**Planning Application No 3/2026/0053**

**Location: Cow Ark Farm, Clitheroe Road, Whitewell, BB7 3DF**

**SUBJECT: Planning Application 3/2026/0053**

A Proposed Roof Plan 1:100

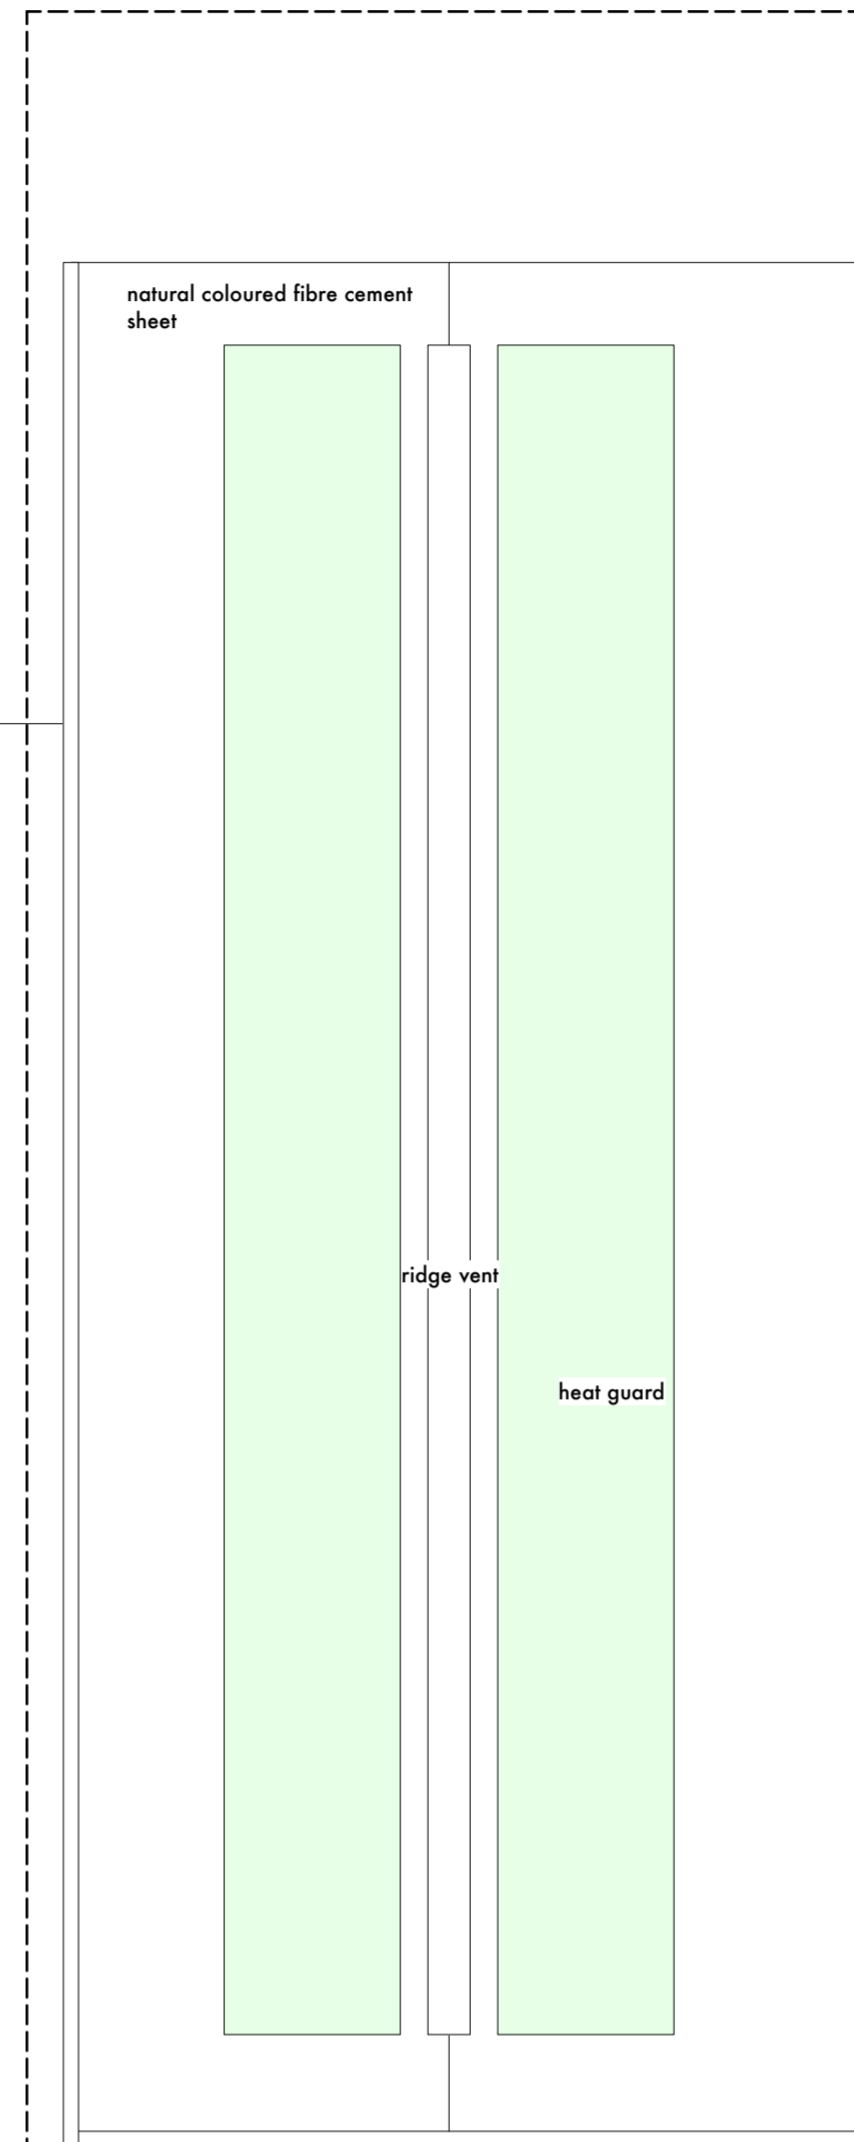
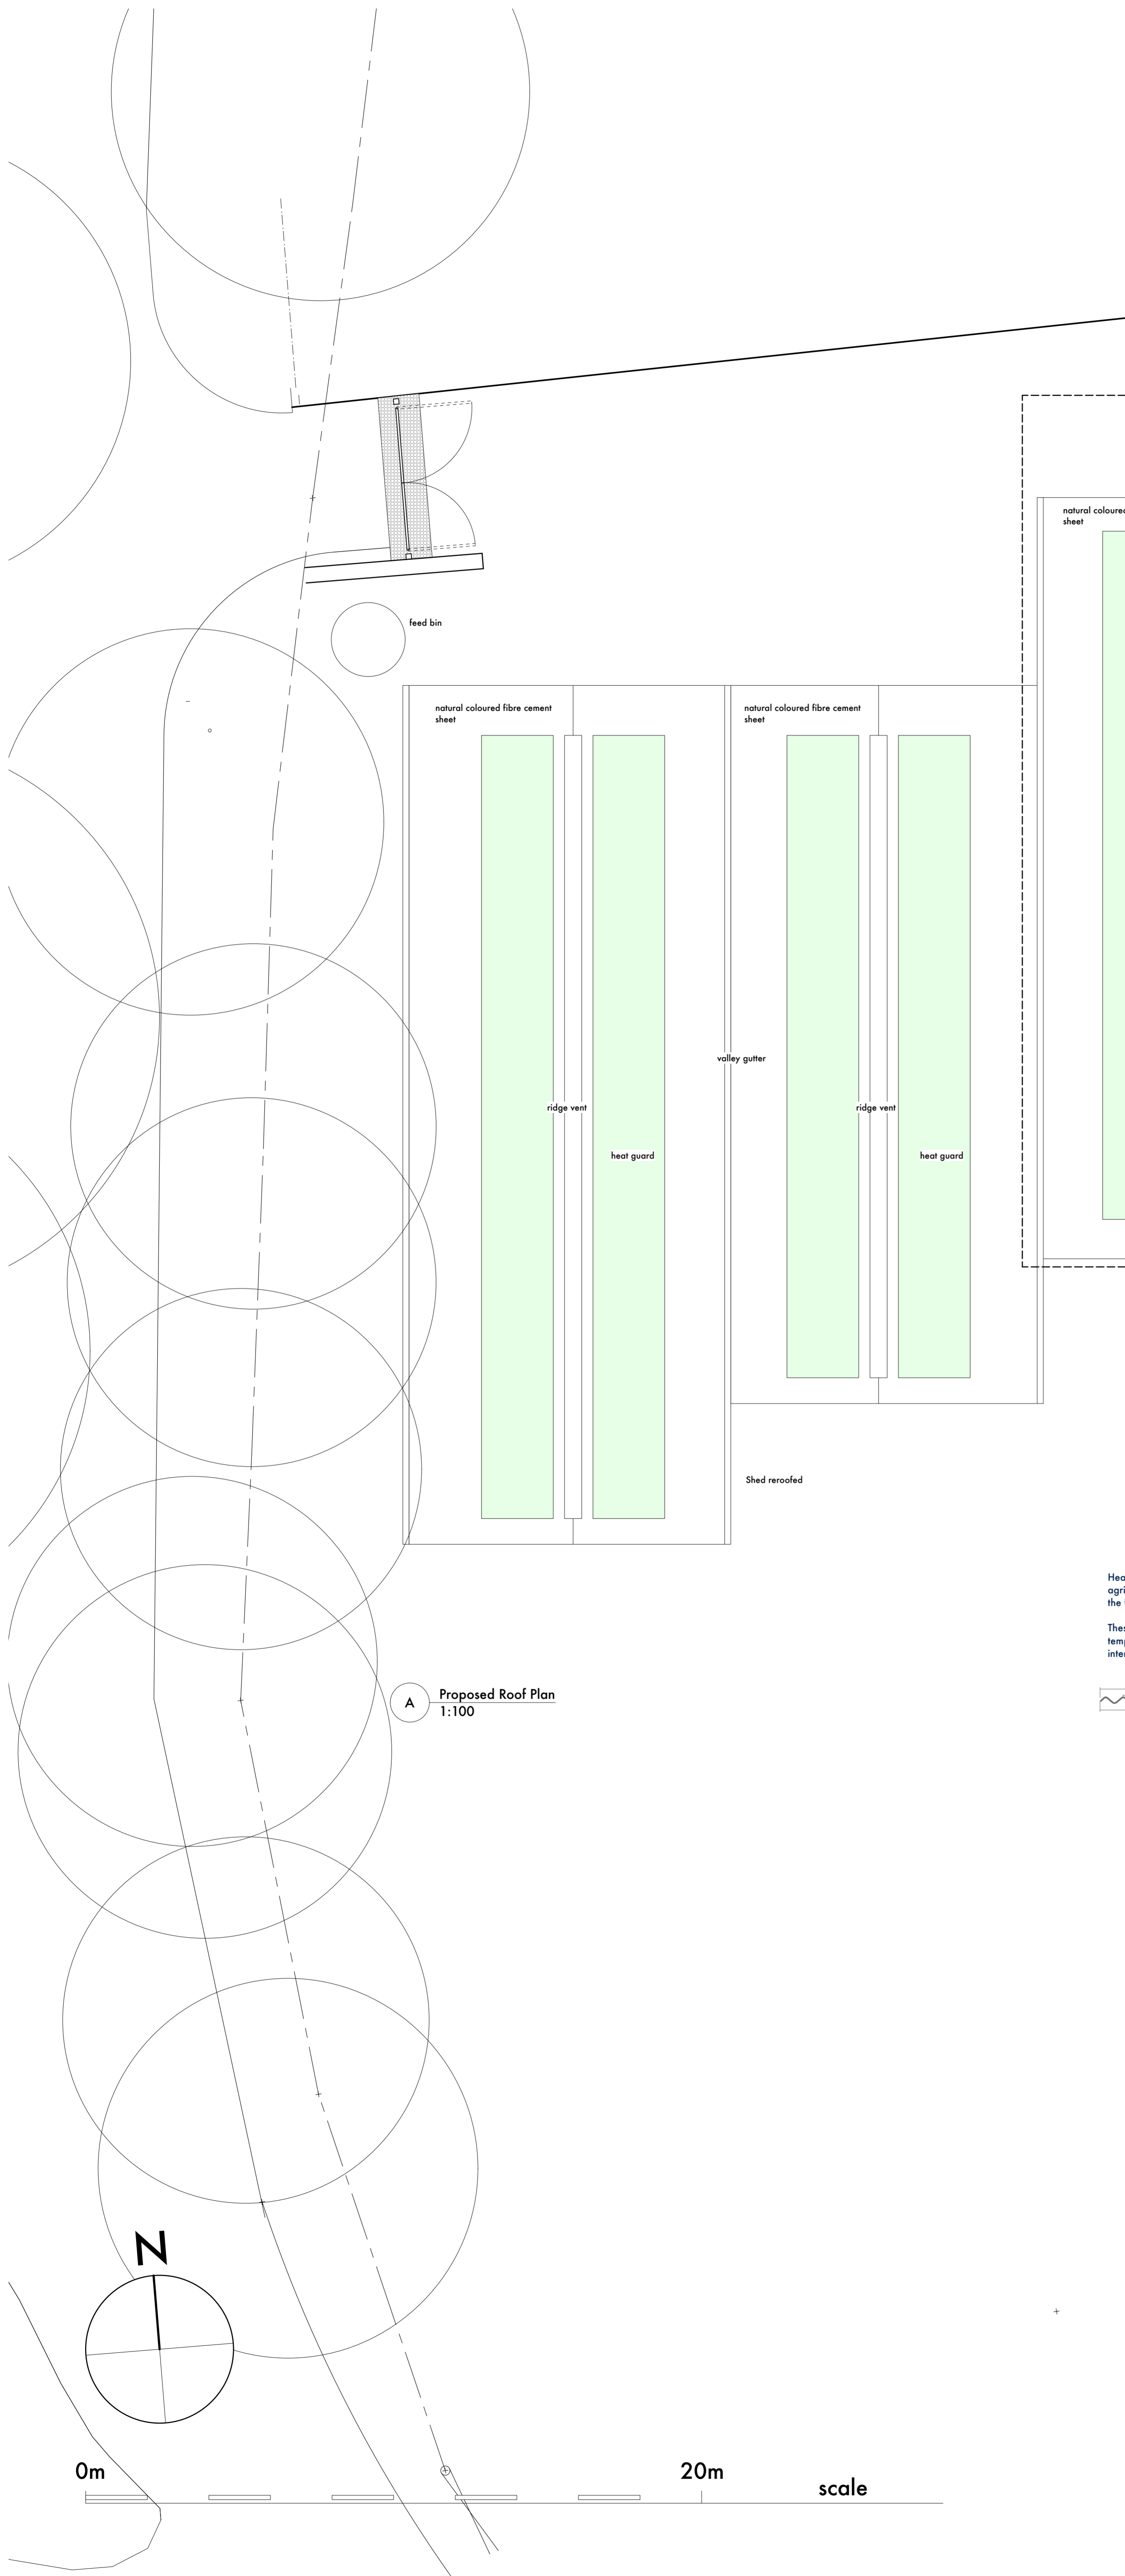
The planning application states that the clean rainwater from the roof is directed into an existing ditch. This is a very large roof area. The ditch is no longer in existence. Historically it did used to be there but a new wall constructed on the boundary of Cow Ark Farm was footed within the ditch. The run off of rainwater from this new roof into a non existent ditch then onto the road is only exacerbating an existing problem. As is it directed through mud it is also not particularly clean and will eventually make its way into Cow Ark Brook. Photos 4 and 5 show the detritus left on the road after rainfall last week. The gravel and stones and mud extend much further than the usual run off demonstrating how the new drainage has increased the problem. Photos 6,7,8 show the drainage from the farm roofs into a “ditch” and down the road towards junction and Cow Ark Bridge.

A drainage strategy is provided, but there are no calculations with regard the quantities of water. This is for either the clean or dirty water. As such it is not possible to determine if there is sufficient capacity in either drainage system to not have detrimental impacts. A lack of capacity in existing surface water drainage adjacent to the property could result in surface water flooding and/or road traffic incidents.
